**From:** lancashire.archaeology <lancashire.archaeology@gmail.com>  
**Sent:** 09 October 2017 09:58  
**To:** Adrian Dowd; planning; info@sunderlandpeacock.com  
**Subject:** Planning applications 3/2017/0776 and 0777 - Newton Hall, Back Lane, Newton in Bowland BB7 3DY

Peter Iles  
Lancashire Archaeological Advisory Service

SECOND FLOOR

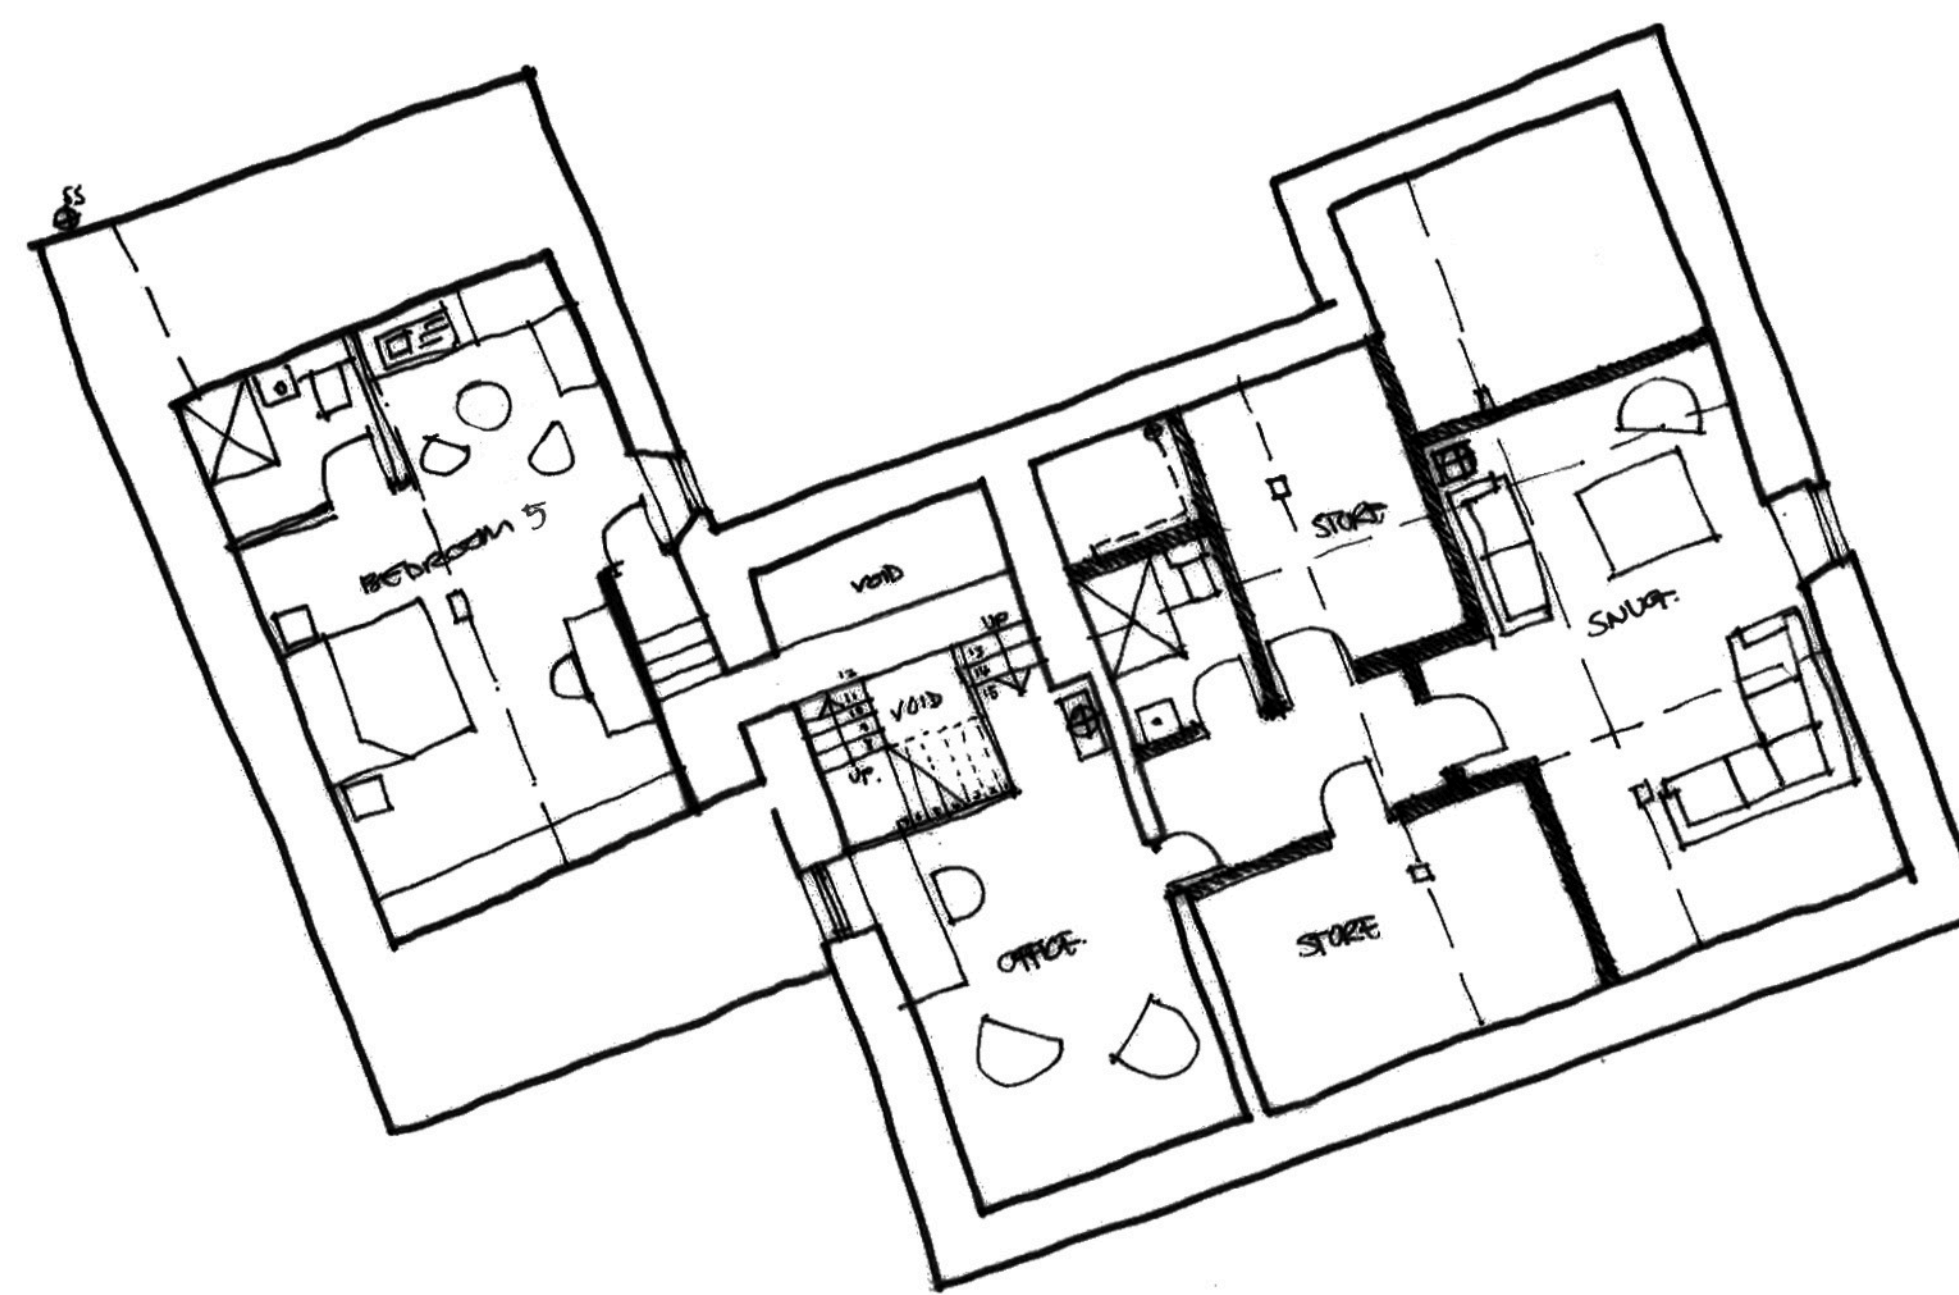
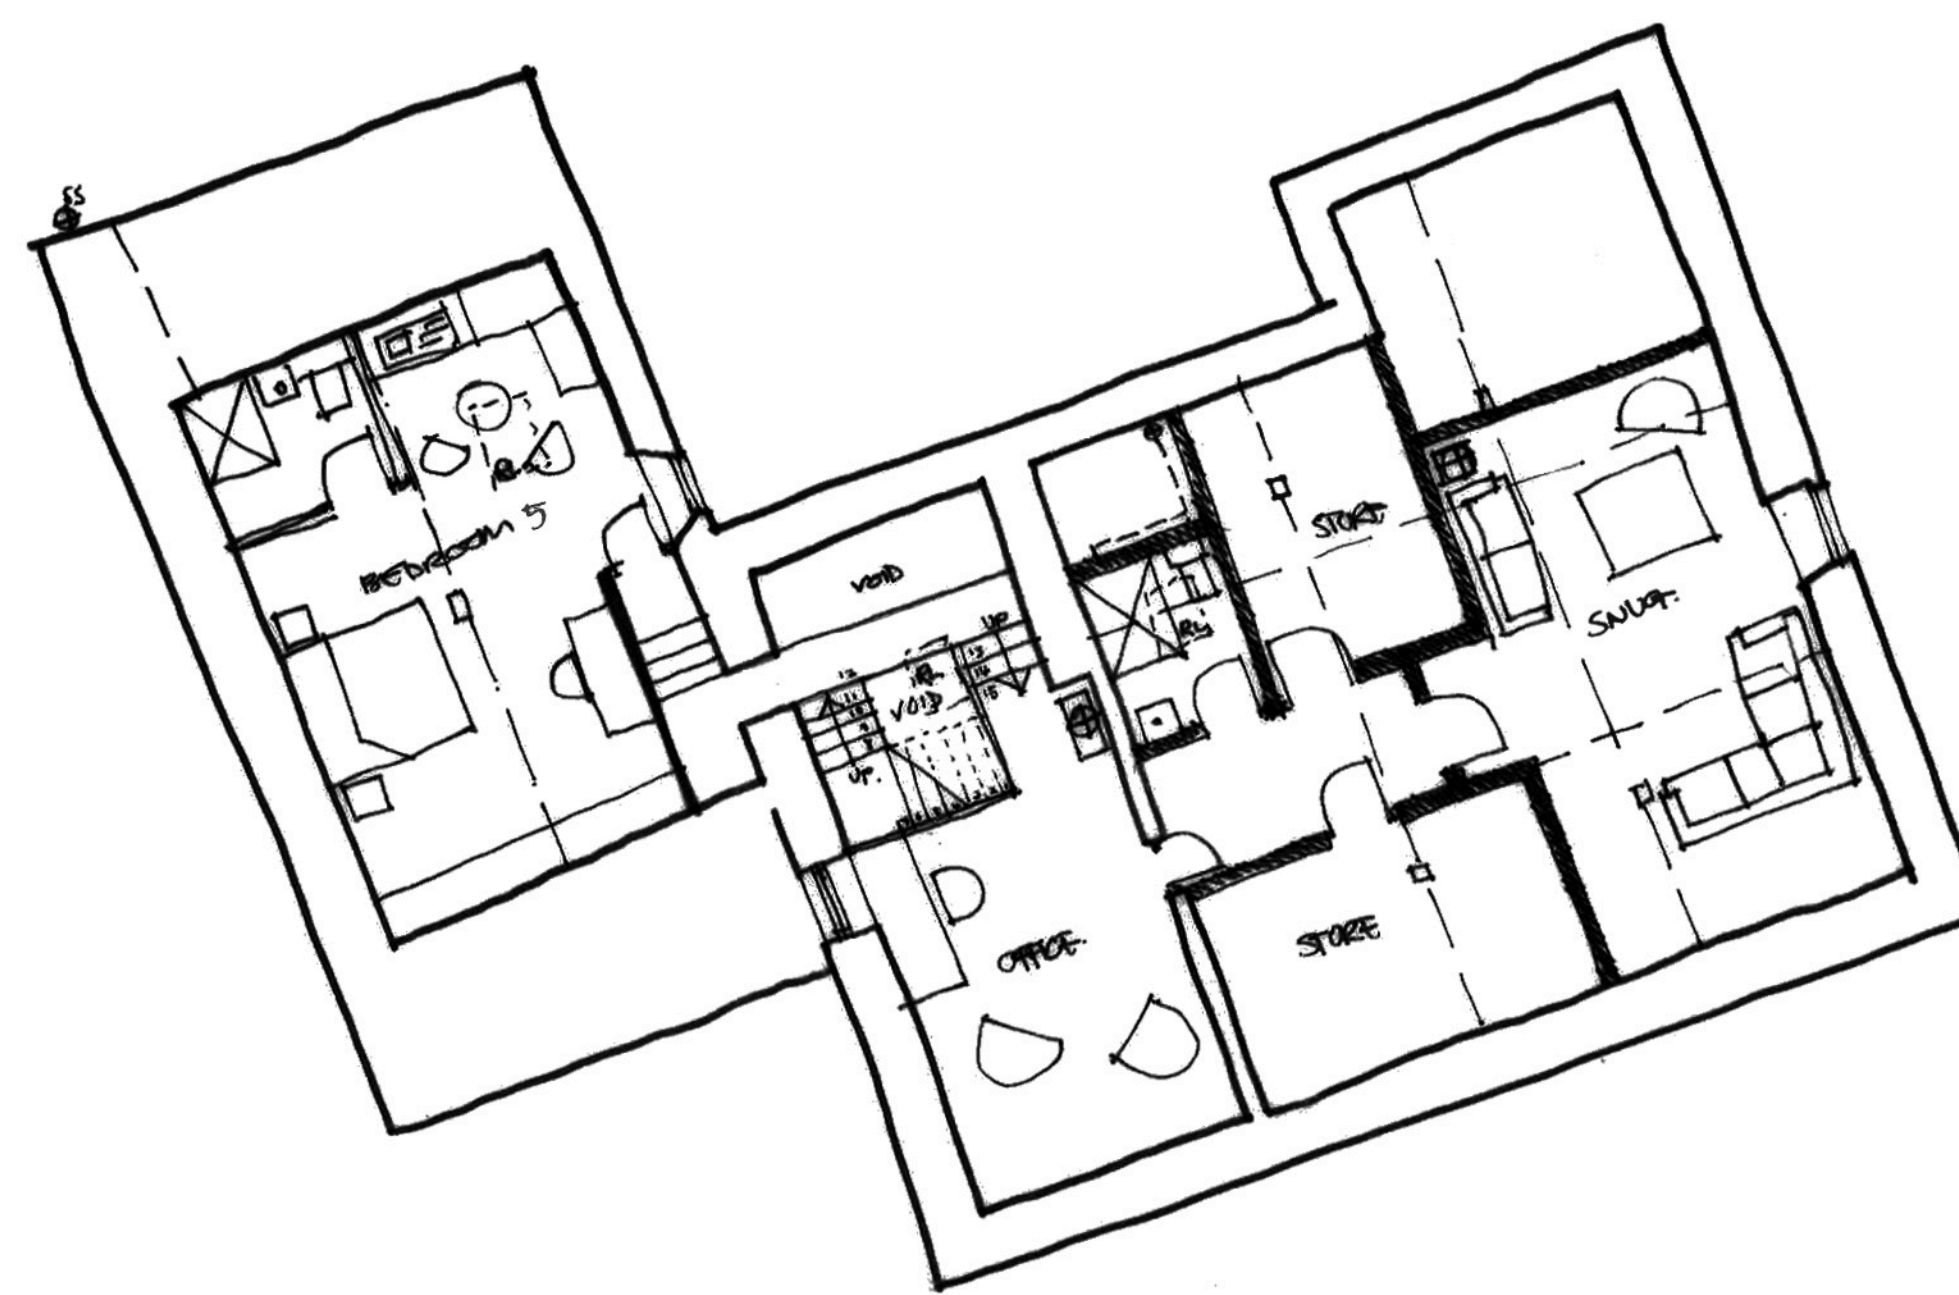
Thank you for your consultation on the above planning application, there appears to be only a minor impact on the significance of the Historic building by the proposed scheme of works, indeed much of the repair and maintenance work is to be welcomed. We have some concerns regarding the impact of the works in the present attic on the historical carpentry there but note that some works have already been permitted and that it is proposed to retain all the extant trusses and purlins as part of the scheme (D and A Statement, p.4).
